From: Michael Flory
Sent: Monday, August 24, 2015 11:07 AM
To: Kaycee Hathaway; Brenda Larsen; Christina Wollman; Holly Myers
Subject: RE: BL-15-00010 Monjazez Notice of Application

Thank you for the opportunity to comment on BL-15-00010 Monjazez.

RECORD OF SURVEY
A PORTION OF THE WEST 1/2 OF SECTION 21,
TOWNSHIP 21 NORTH, RANGE 14 EAST, W.M.
KITITAS COUNTY, WASHINGTON

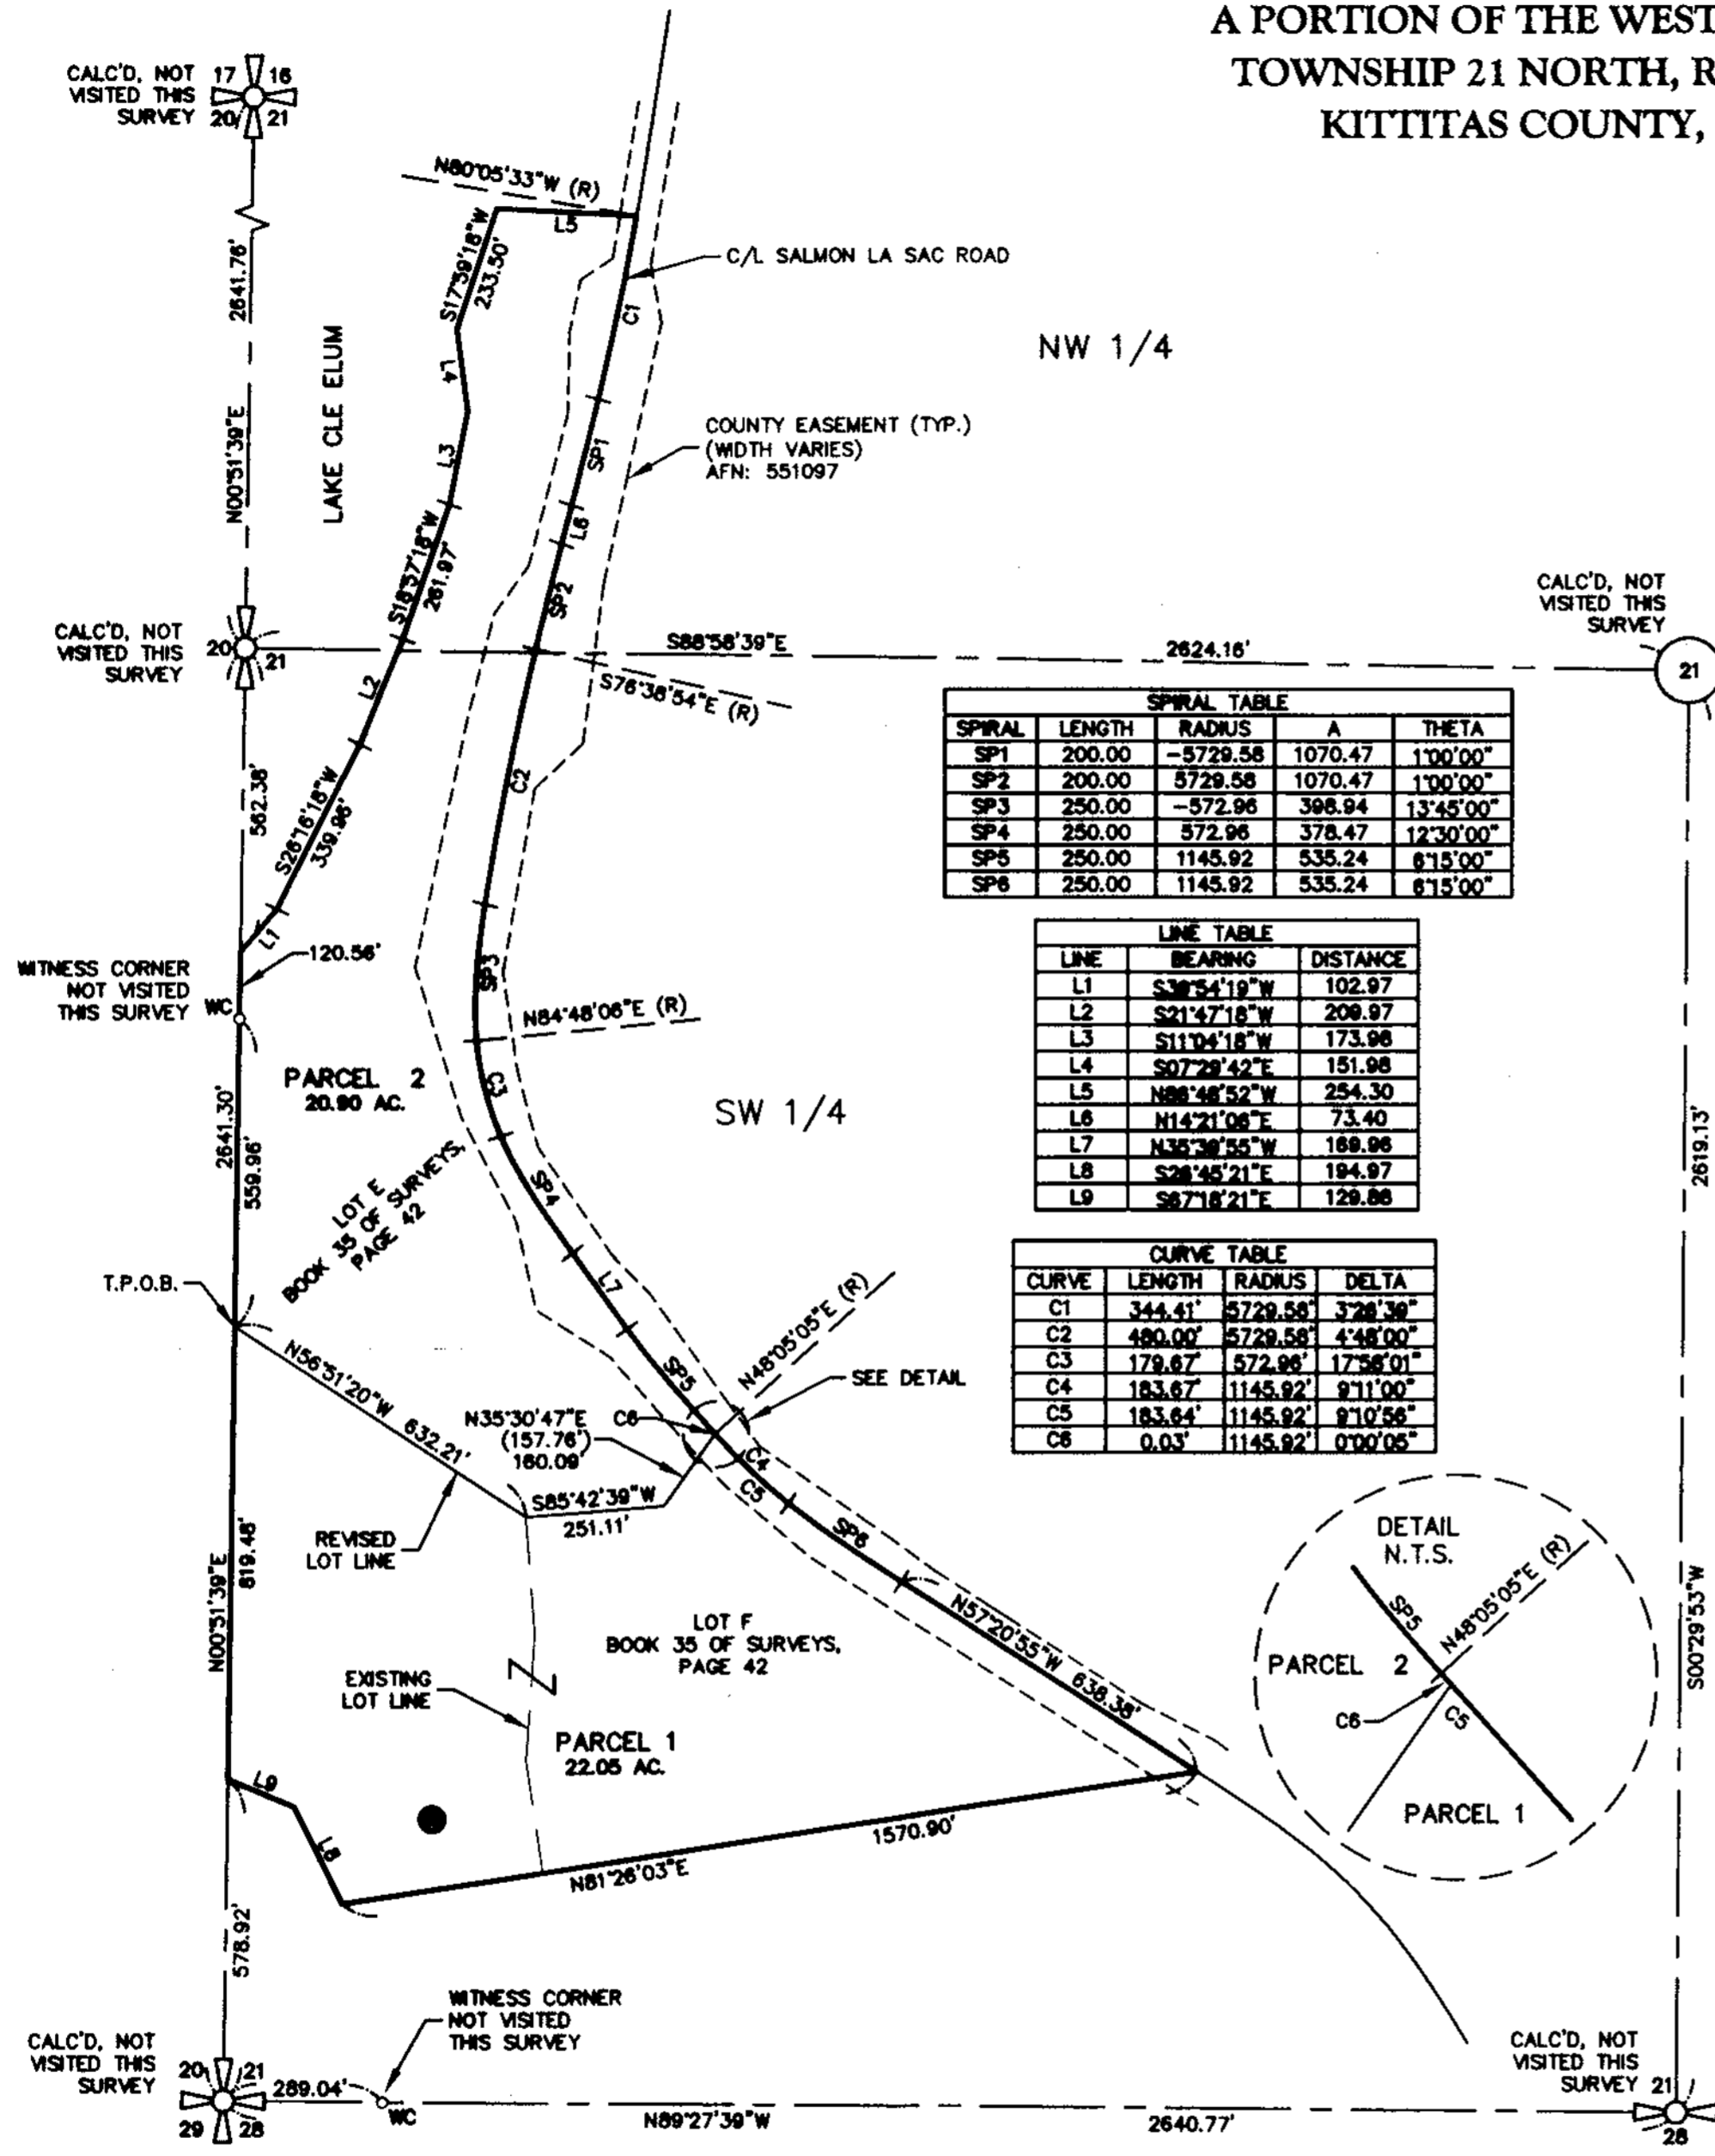
If any area of development occurs within the hazardous slope area measuring more than 33% slope, specialized engineering will be required for soils, retaining walls and footings/foundations as stipulated in IRC 403.1.7.
